From: Alex Cole [REDACTED]
Sent: 24 August 2021 15:05
To: Anita Gardner <Anita.Gardner@arun.gov.uk>
Cc: Serena Page [REDACTED] Charlie Merry [REDACTED]
Subject: RE: Planning Consultation on: A/26/21/RES

Application ref: A/26/21/RES

Location: Land west of Brook Lane and South of A259 Angmering BN16 3JL

TOWN AND COUNTRY PLANNING (DEVELOPMENT MANAGEMENT PROCEDURE) (ENGLAND) ORDER 2015: APPLICATION FOR THE APPROVAL OF RESERVED MATTERS IN RESPECT OF OUTLINE PERMISSION ALLOWED AT APPEAL (APP/C3810/W/17/3185128) AT LAND SOUTH WEST OF BROOK LANE AND SOUTH OF A259, RUSTINGTON

Refer to drawing 176-012 for LEAP General Arrangement Plan.

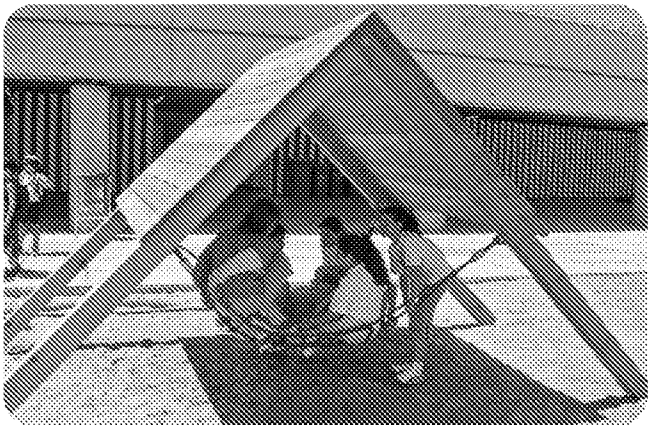
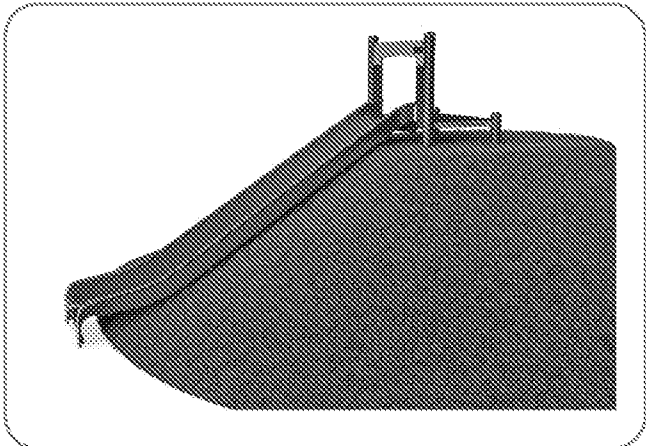
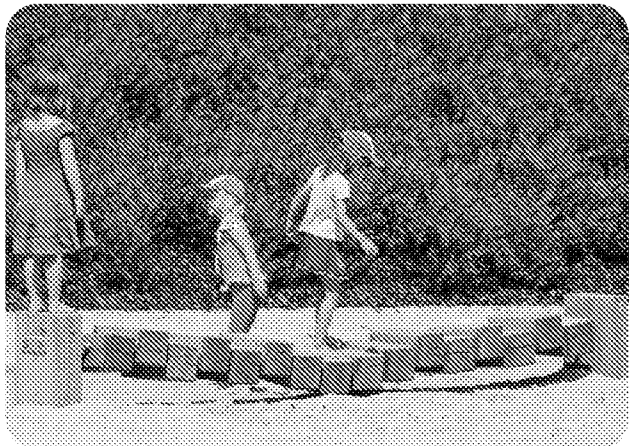
- Landscape Plan 176-003 Rev P3 has detail of LEAP however this information is not sufficient in detail and needs to be provided in separate plan form detailing equipment choice, fencing and surfacing proposed. This information needs to be consistent with that shown in the revised DAS. Play equipment for a LEAP catering for 90no dwellings needs to provide for a good variety of play experience, be accessible and inclusive, providing also seating and bins and fencing as appropriate. This applies also to the 3no LAPs which are shown within the scheme.

"Landscape Plan 176-003 Rev P3 has detail of LEAP however this information is not sufficient in detail and needs to be provided in separate plan form detailing equipment choice, fencing and surfacing proposed. This information needs to be consistent with that shown in the revised DAS. Play equipment for a LEAP catering for 90no dwellings needs to provide for a good variety of play experience, be accessible and inclusive, providing also seating and bins and fencing as appropriate. This applies also to the 3no LAPs which are shown within the scheme."

DRAWING/REPORT TITLE	REFERENCE NUMBER
General Arrangement Plan LEAP	176-012 P1
General Arrangement Plan LAP1	176-013 P1
General Arrangement Plan LAP2	176-014 P1

General Arrangement Plan LAP3	176-015 P1
Play Areas – Equipment and Proposal	176-102
